CITY OF ALBUQUERQUE

October 31, 2017

**Re: McMahon Taproom and Shell Building
Erosion and Sediment Control Plan
Engineer's Stamp Date 10-25-17 (A11E011H)**

EROSION AND SEDIMENT CONTROL PLAN

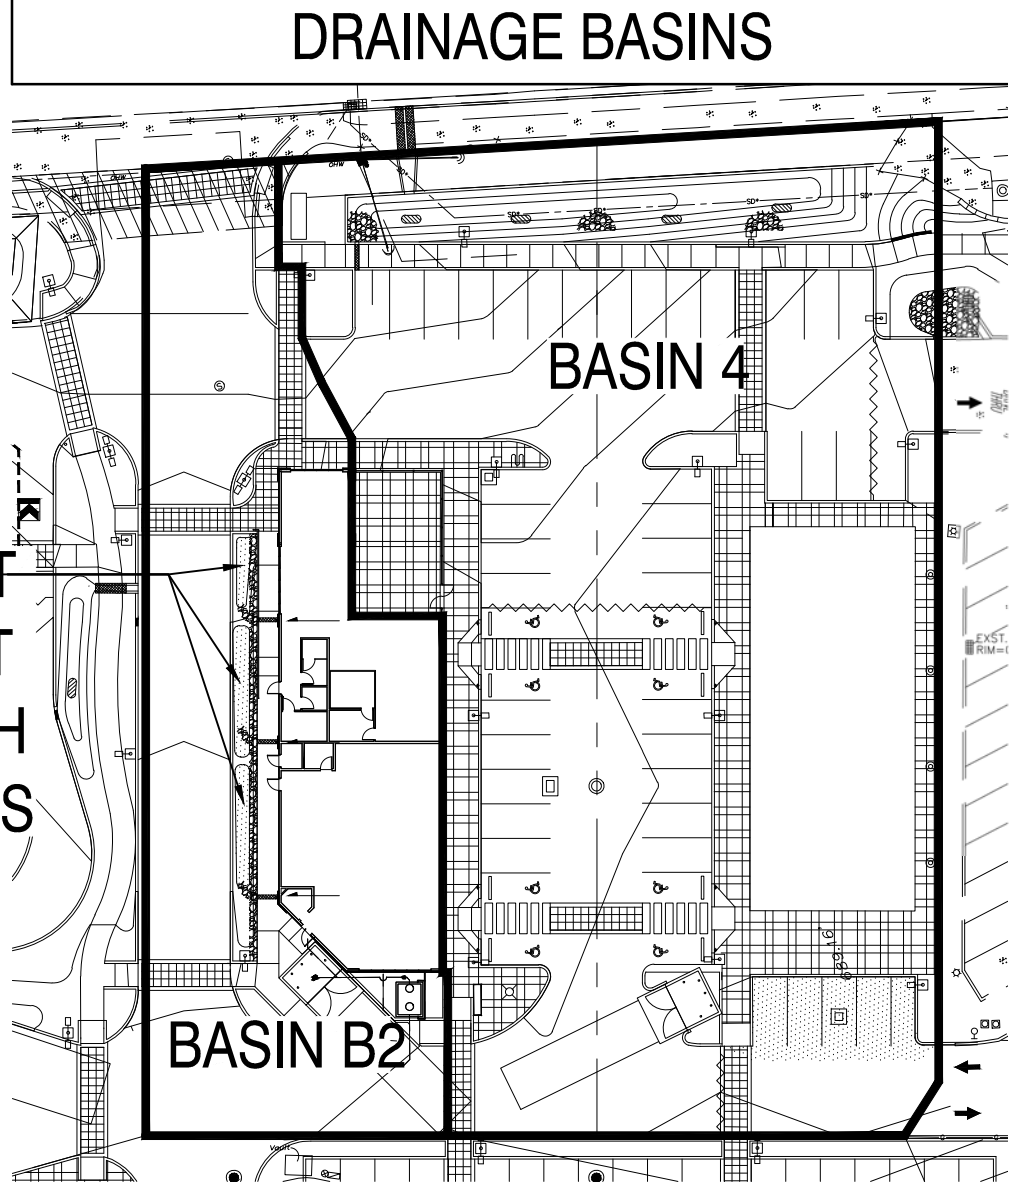
Based upon the information provided in your submittal received 10-25-17, the above referenced plan is not approved to be included in the SWPPP or to apply for an ESC Permit for grading and Building Permit until the following comments are addressed:

1. A sediment BMP should be proposed at the north end and along the western edge of the access road along the western side of the project (BMP on PB).
2. Grading is proposed south of the Project Boundary and silt fence. Should a sediment BMP be proposed along the western edge of this disturbed area?
3. Propose a BMP for the construction (storm drain to inlet and sidewalk culverts) adjacent to McMahon Blvd.
4. The silt fence and Project Boundary should be adjusted in the northeast corner to include the grading on the adjacent lot.
5. Consider moving the track-out pad to the southeast corner of the site. It is currently proposed at a relative low-spot on the site.
